**KIRKLEES METROPOLITAN COUNCIL  
INVESTMENT & REGENERATION SERVICE**

**DELEGATED DECISION TO DETERMINE PLANNING APPLICATIONS**

Reference No:	<b>2025/62/90477/W</b>
Site Address:	8, The Ghyll, Fixby, Huddersfield, HD2 2FE
Description:	Demolition of existing conservatory and erection of single storey rear extension with associated external alterations
Recommending Officer:	Jennifer Booth

## **OFFICER REPORT**

**0110**

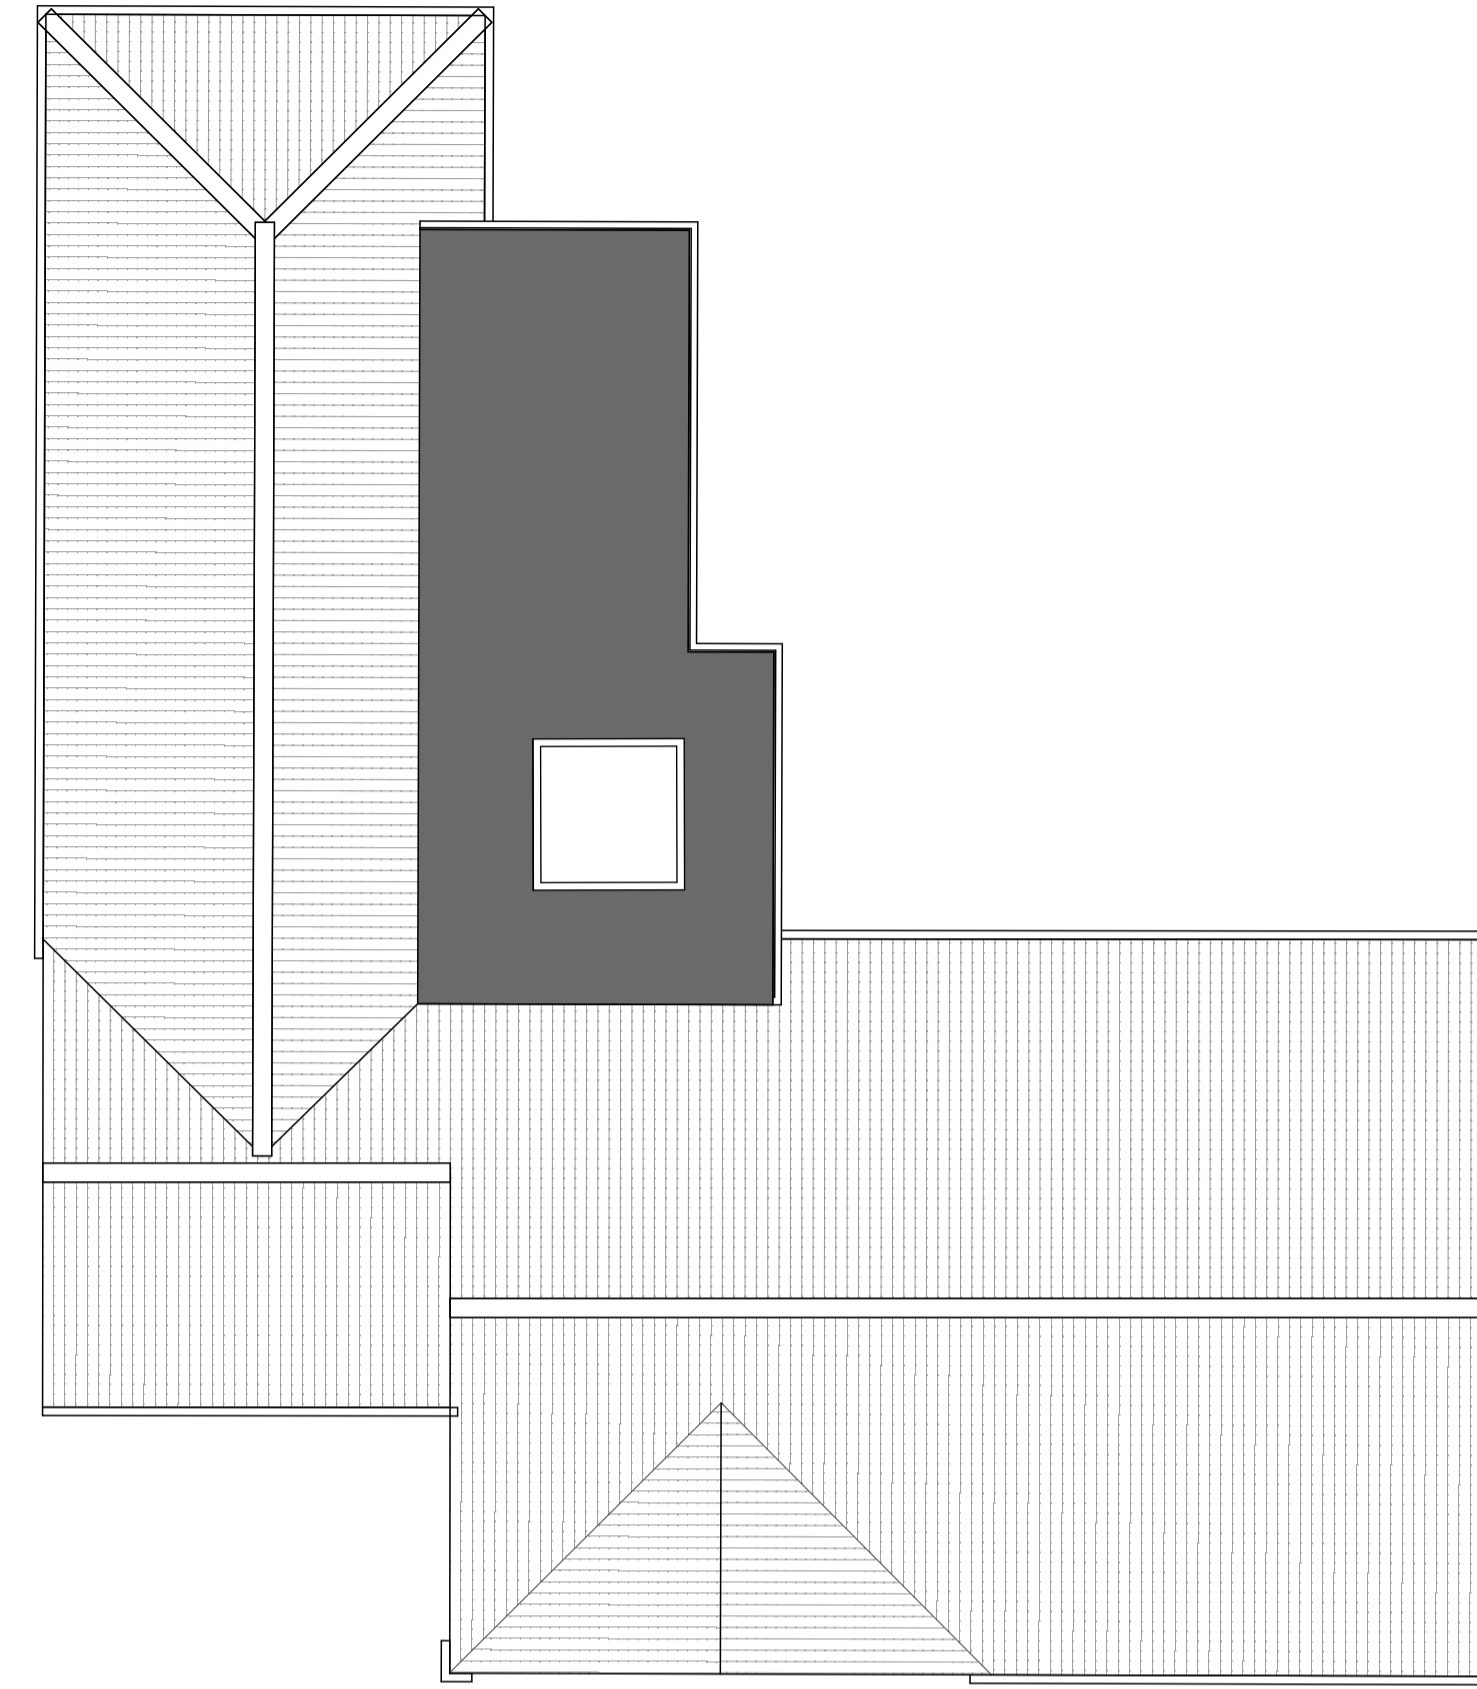
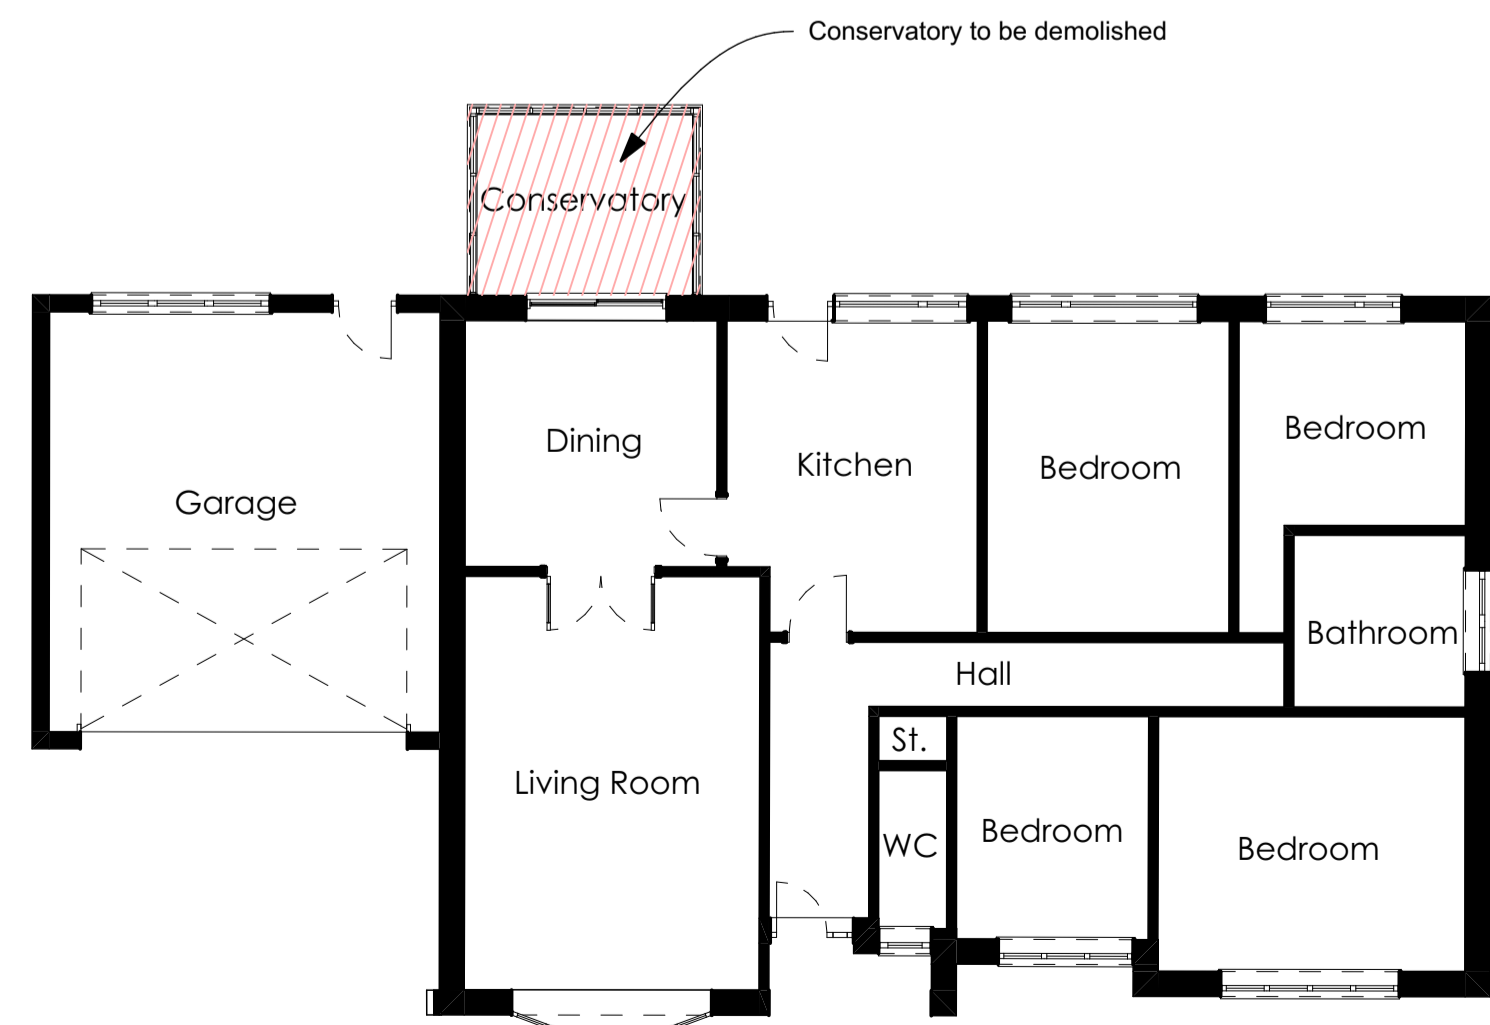
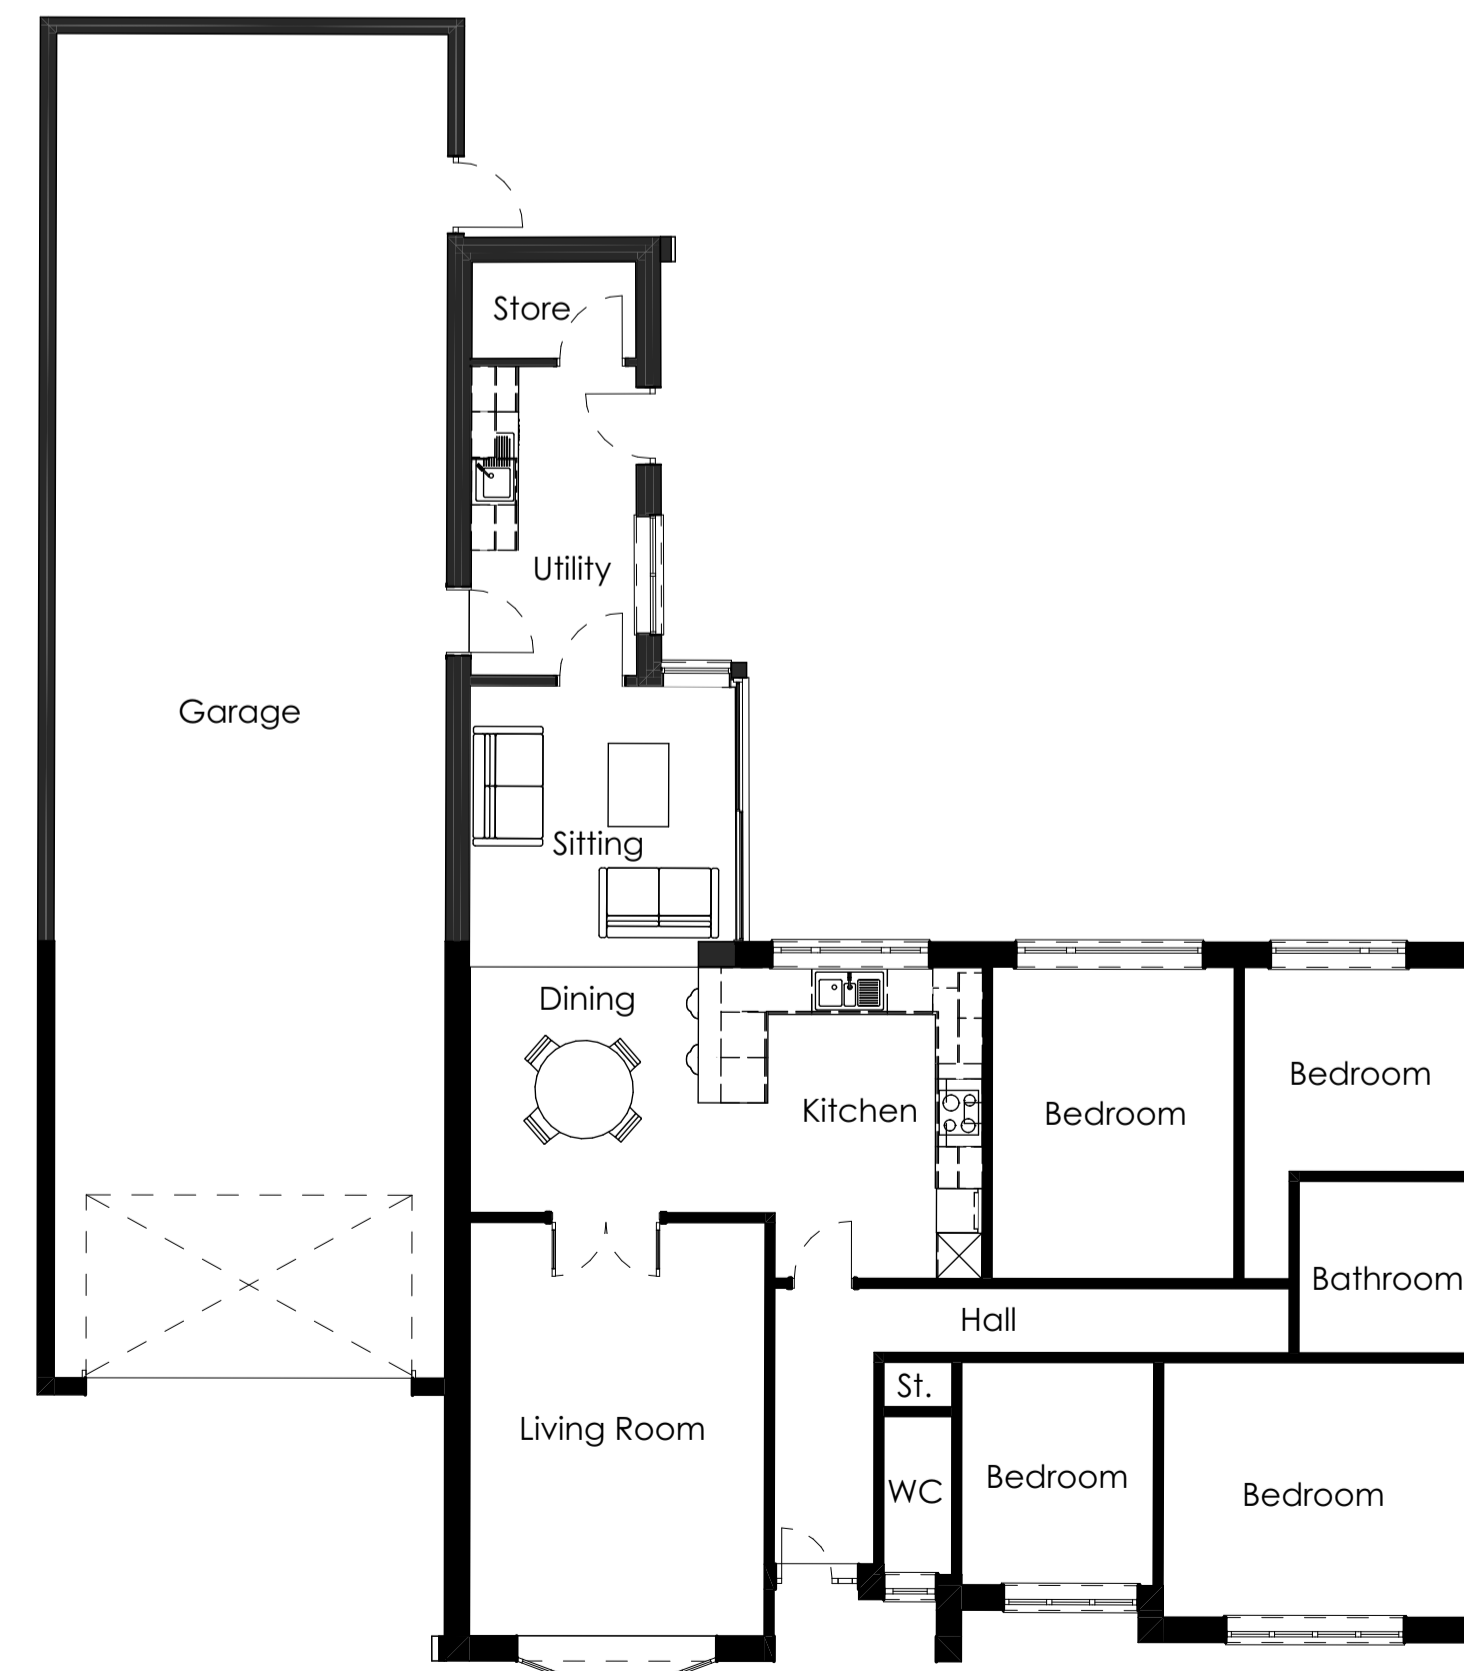
The initially submitted plans raised concerns in terms of the scale and design. Amended plans have been sought and received which reduced the projection and amended the roof design. The alterations reduced the scheme and as such the amended plans have not been advertised.

0110

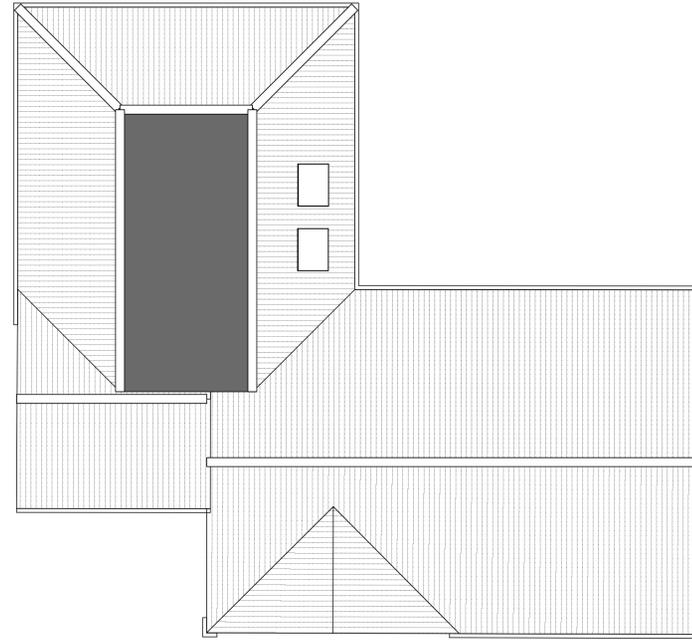
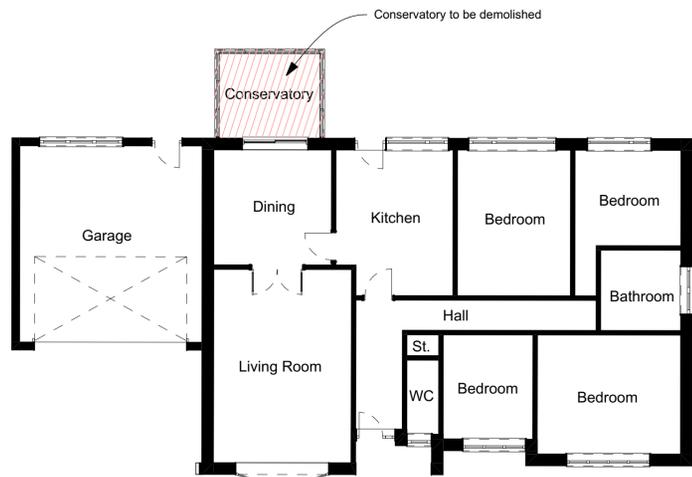
The proposed rear extension does have a sizeable projection of 8m. However, the host property itself is a larger dwelling with large gardens. As such, the extension would be proportionate to the main house. The materials proposed include the use of stone for the walling and tiles for the roof covering which would match the host property. The detailing including the fenestration and roof form would form an appropriate relationship with the dwelling. The rear extension is therefore considered to be acceptable in terms of visual amenity.
